Subject: FW: FW: Planning Consultation on: AL/37/20/DOC

Engineers Comments Regarding Surface Water Drainage

Application No:	AL/37/20/DOC
Registered:	4th May 2020
Site Address:	Forge House Nyton Road Westergate PO20 3UP
Grid Reference:	494185 105564
Description of Works:	Approval of details reserved by condition imposed under ref APP/C3810/W1/3213581 (AL/129/17/PL) relating to Condition No 3 - surface water drainage

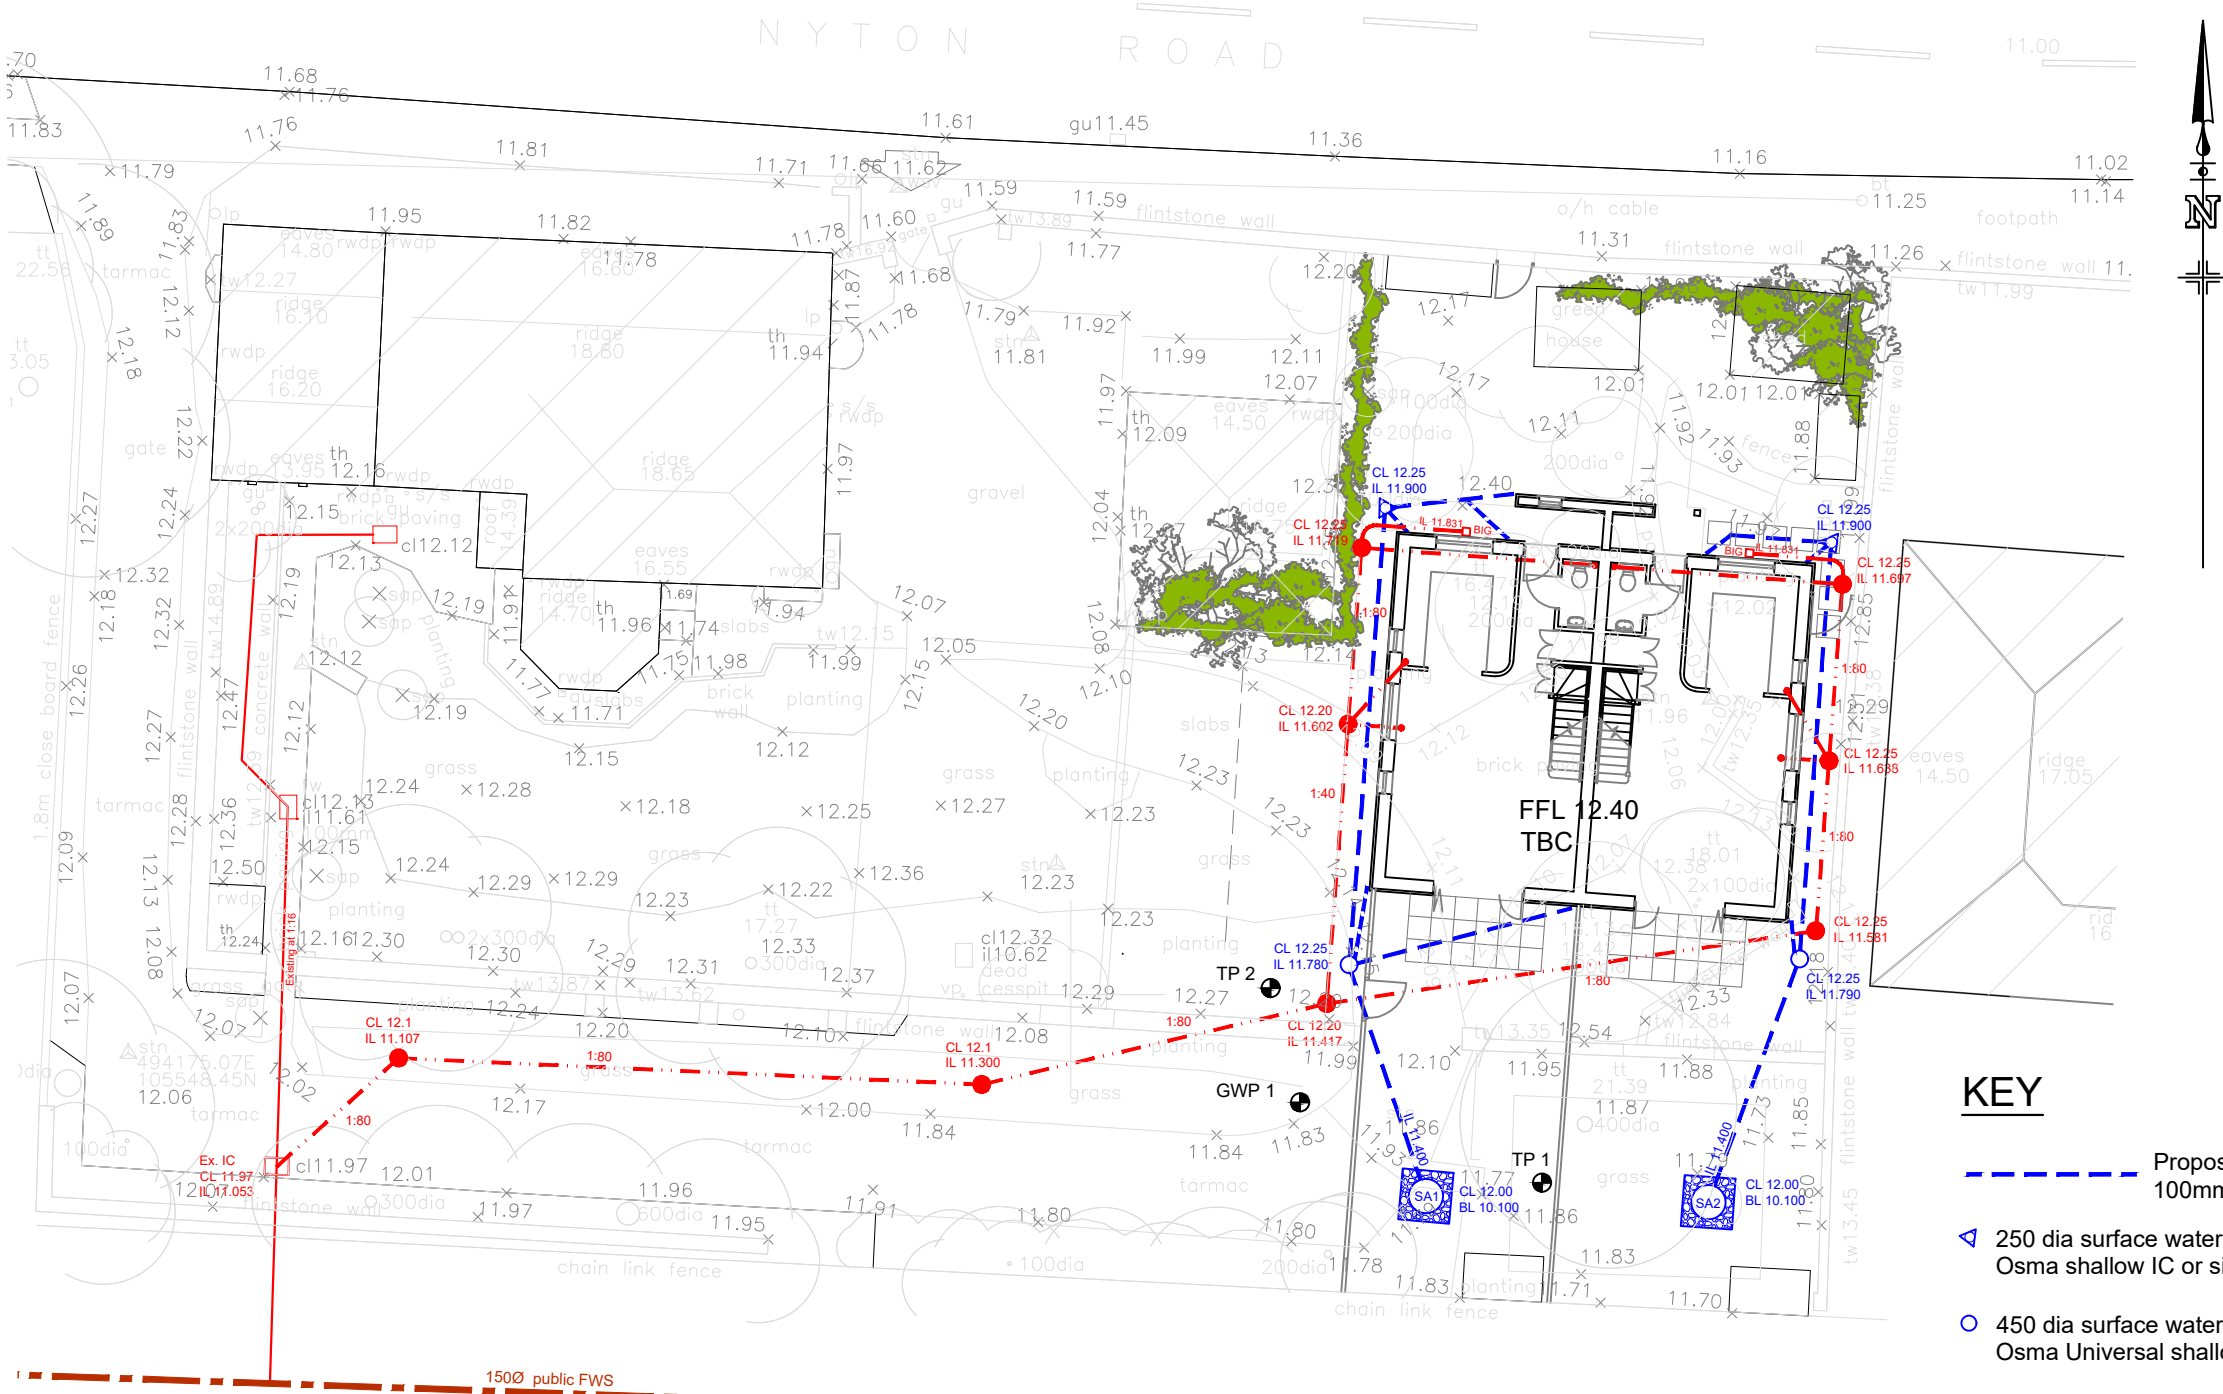
1. Please provide silt traps (or sumps on inspection chambers) upstream of the soakaways. Whilst it is acknowledged that the concrete ring soakaways are accessible for clearance, silt traps are easier to clear.
2. Please provide a construction detail for a concrete pipe bed and surround for where pipe depths are less than 900mm. Plus amend note as to when each surround should be used (Granular where cover to crown is greater than 1200mm in vehicular areas, or greater than 900mm elsewhere. For shallower depths concrete surround.)
3. Please provide a construction detail for the inspection chambers, and silt traps (see point 1).
4. Please confirm the dimensions of the trial pits within the Surface Water Drainage Notes.
